Application No: BR/83/22/PL  
Site Address: Unit 10 Arun Business Park Shripney Road Bognor Regis PO22 9SX  
Description of works: Addition of two first floor windows at rear of property. This application is in CIL Zone 4 (Zero Rated) as other development.

Thank you for your internet representation made on 30th April 2022 which has been recorded as an objection with the comments as follows:

Proposed Office Layout
Option #1

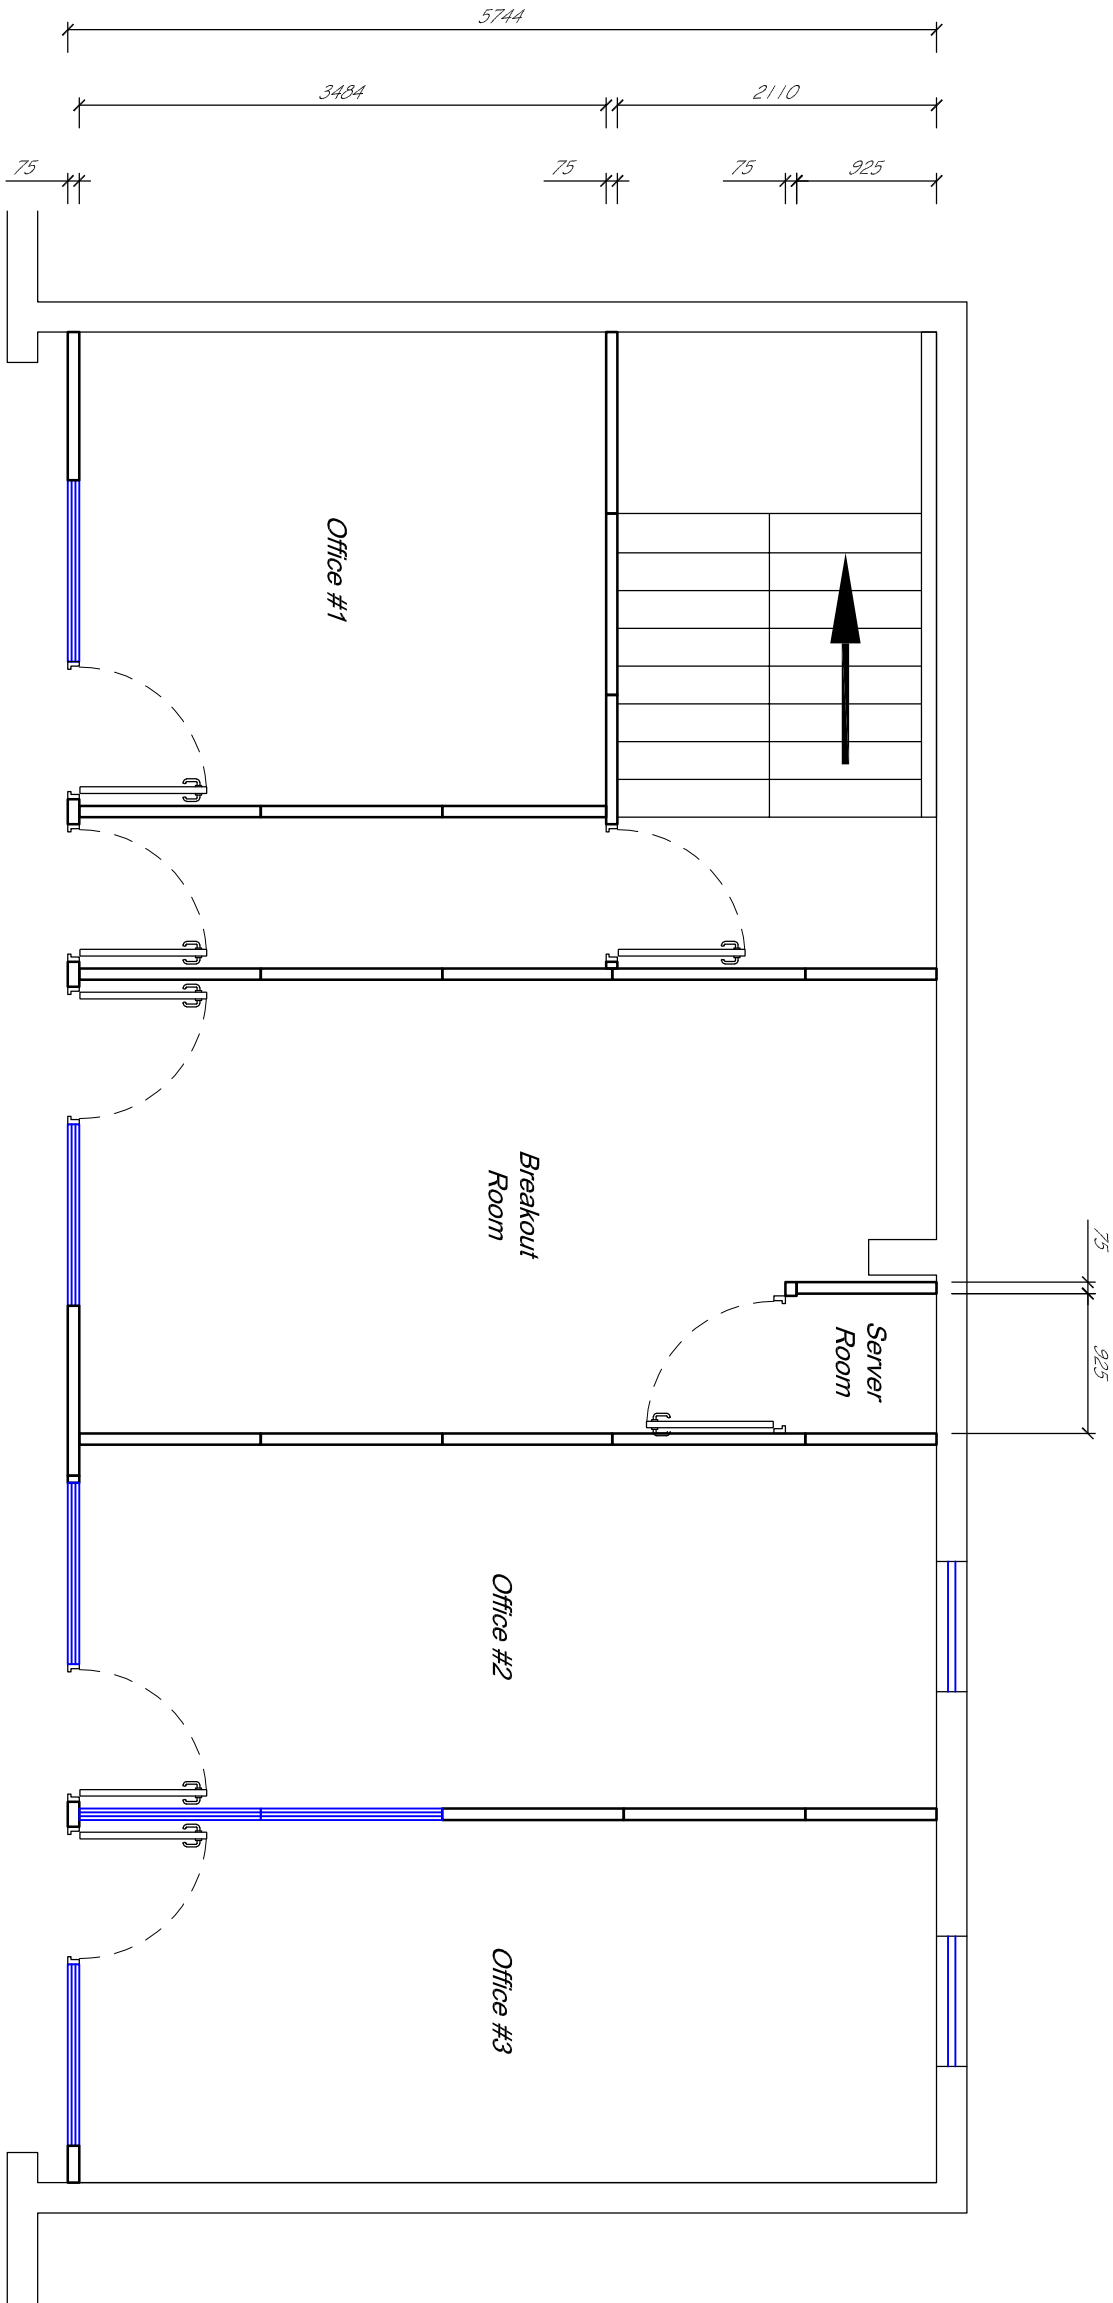
This would overlook our garden and give them views into our bedrooms/bathroom. We would lose privacy. This would also devalue our property. We strongly object. If they need more light then roof sky lights would be more appropriate.
